**Re: McDonald's Restaurant at 9500 Universe Blvd NW
Erosion and Sediment Control Plan
Engineer's Stamp Date 2/20/2024 (B10E003C3B)**

Based upon the information provided in your submittal received on 3/8/24, the above-referenced ESC Plan cannot be approved until the following comments are addressed.

C3.0 SWPPP PLAN

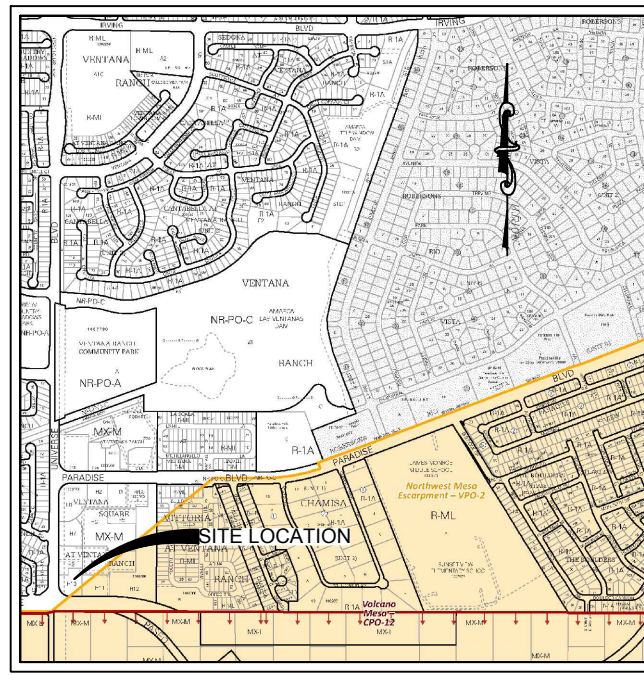
3. The final grades are missing from the ESC Plan. The existing and proposed grades must be shown on the ESC Plan, and they must agree with the Grading Plan approved by Hydrology per CGP 7.2.4.b.ii.

5. Update the engineer's stamp date each time the plan changes

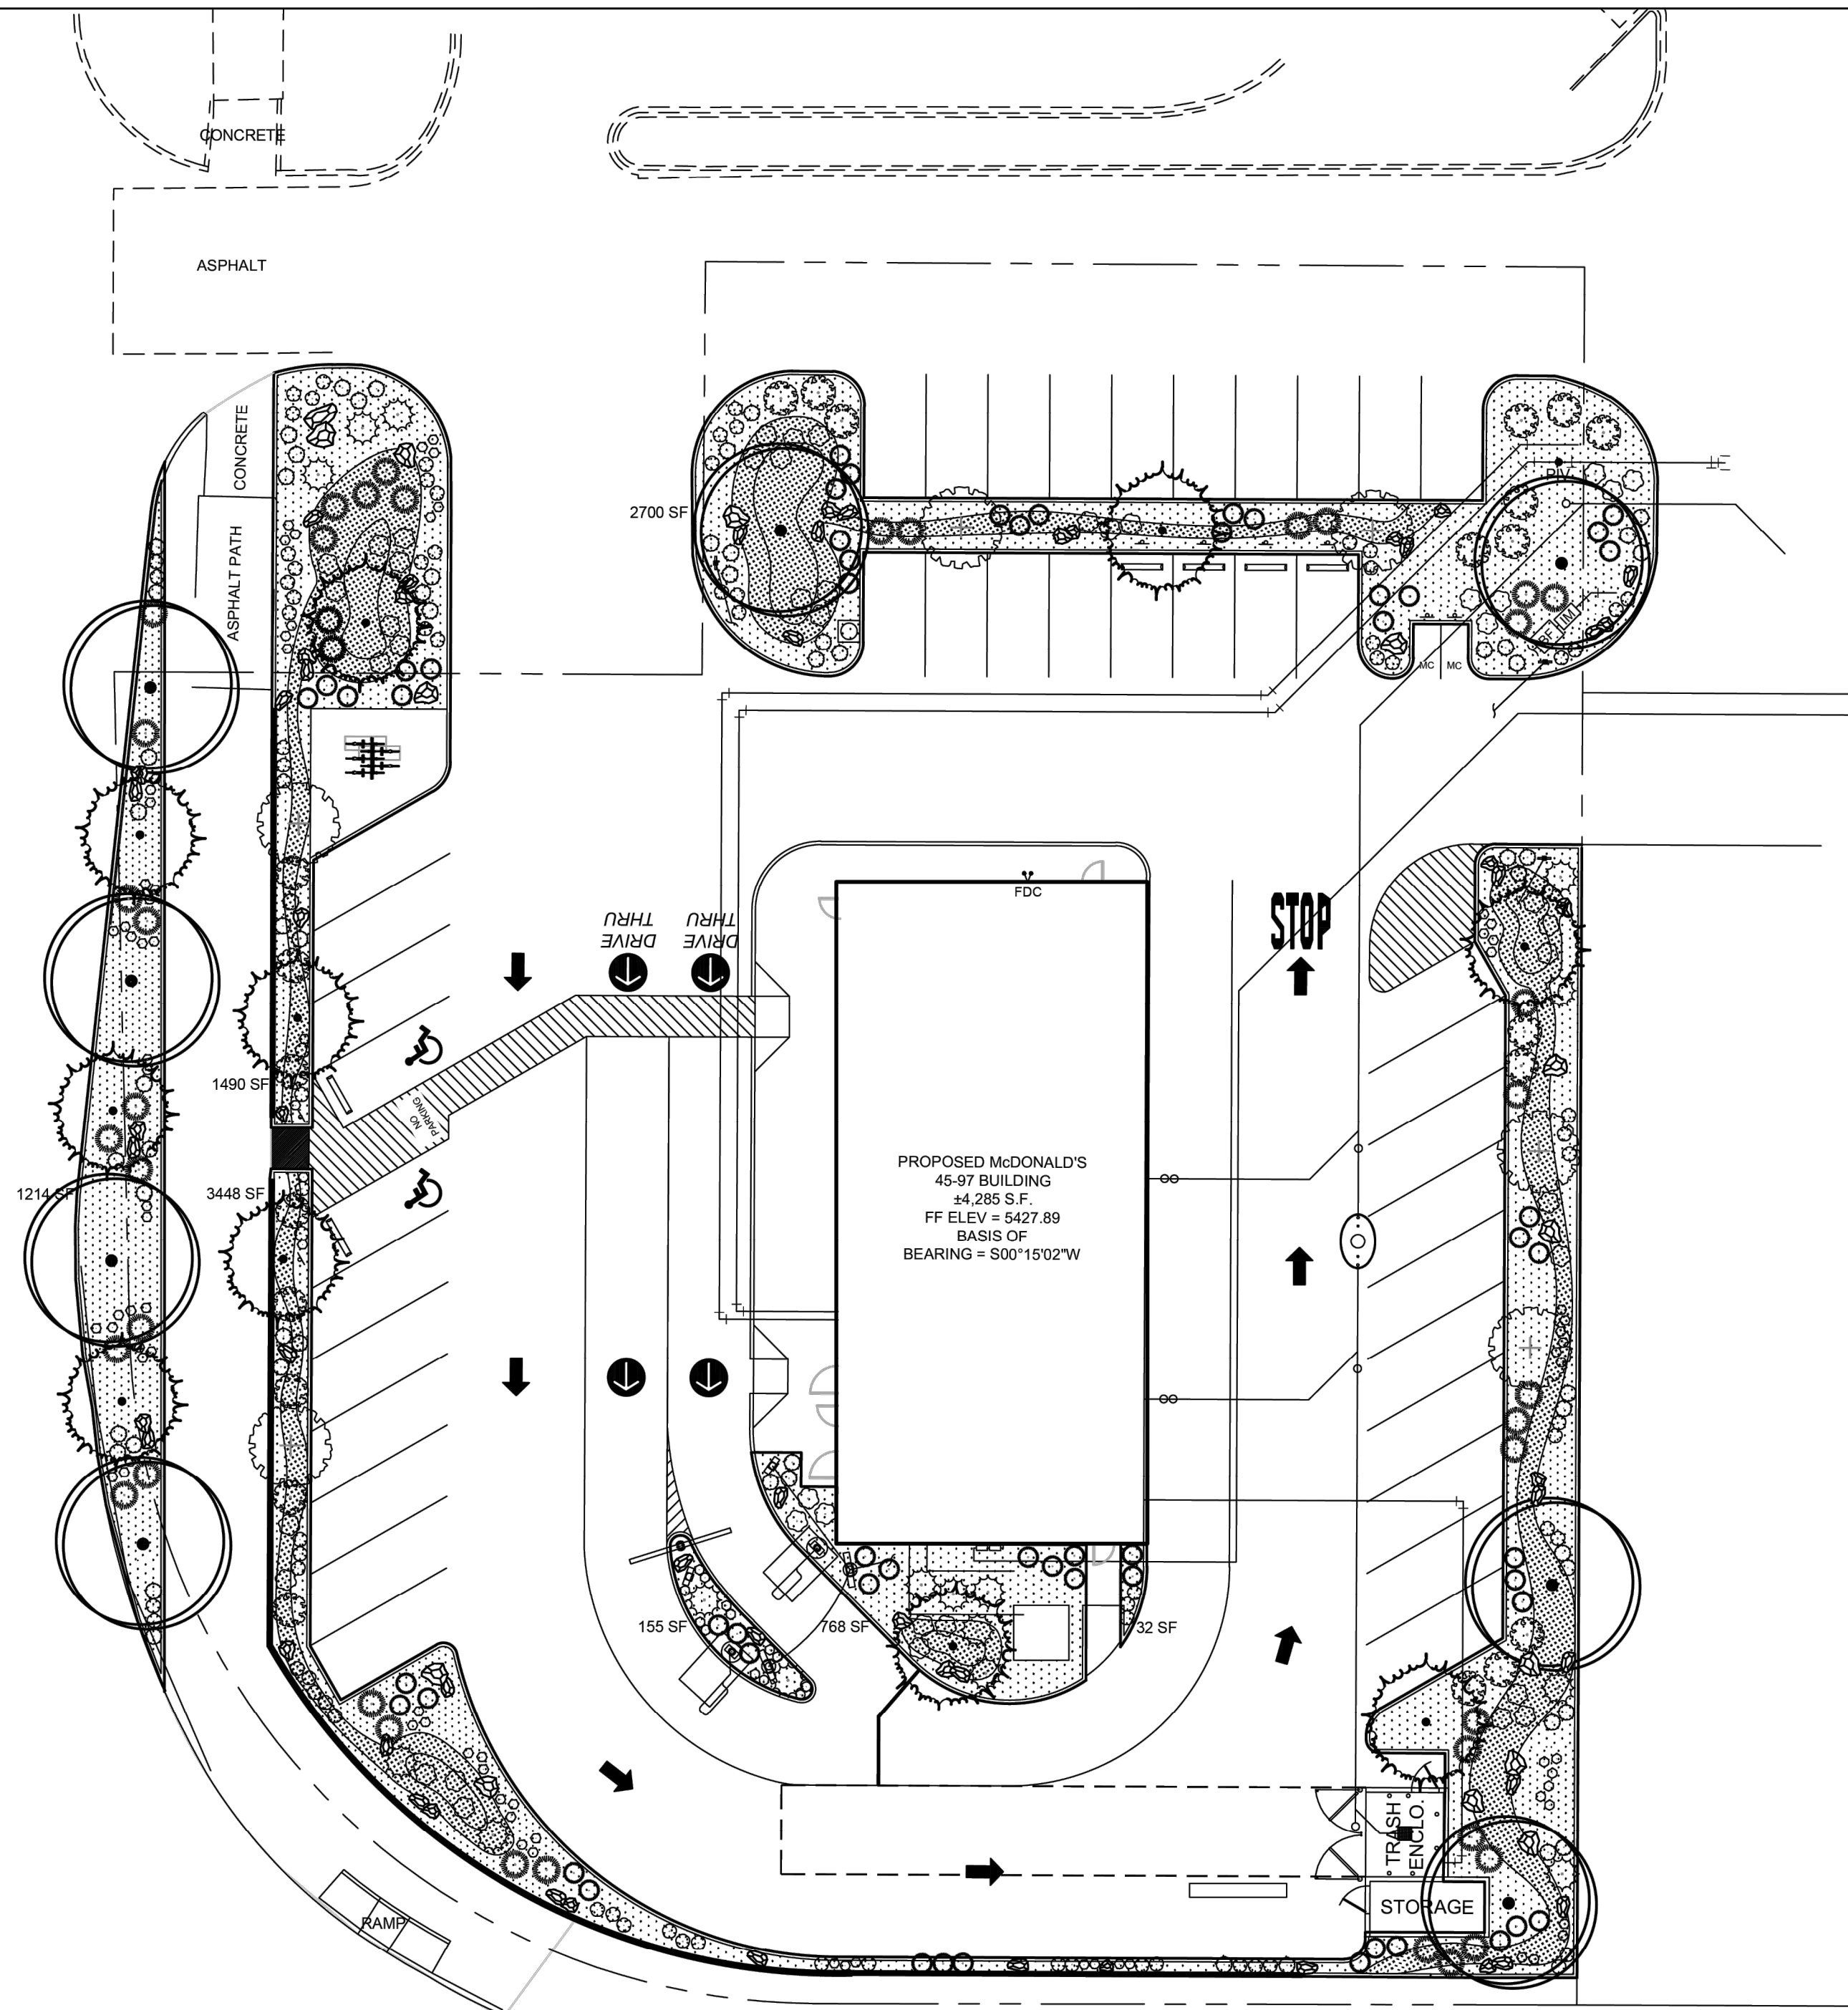
4. The SWPPP must include site-specific interim and permanent stabilization specifications per CGP 9.6.1.c.i. The Landscape Plan and/or Site Plan can be used to satisfy this requirement and should be submitted separately from the ESC Plan with the application to the Stormwater Quality Section of the Planning Department, and it should be included in the SWPPP. Provide a specification on the ESC Plan for any disturbed areas not covered by the Landscape Plan or Site Plan sheets.
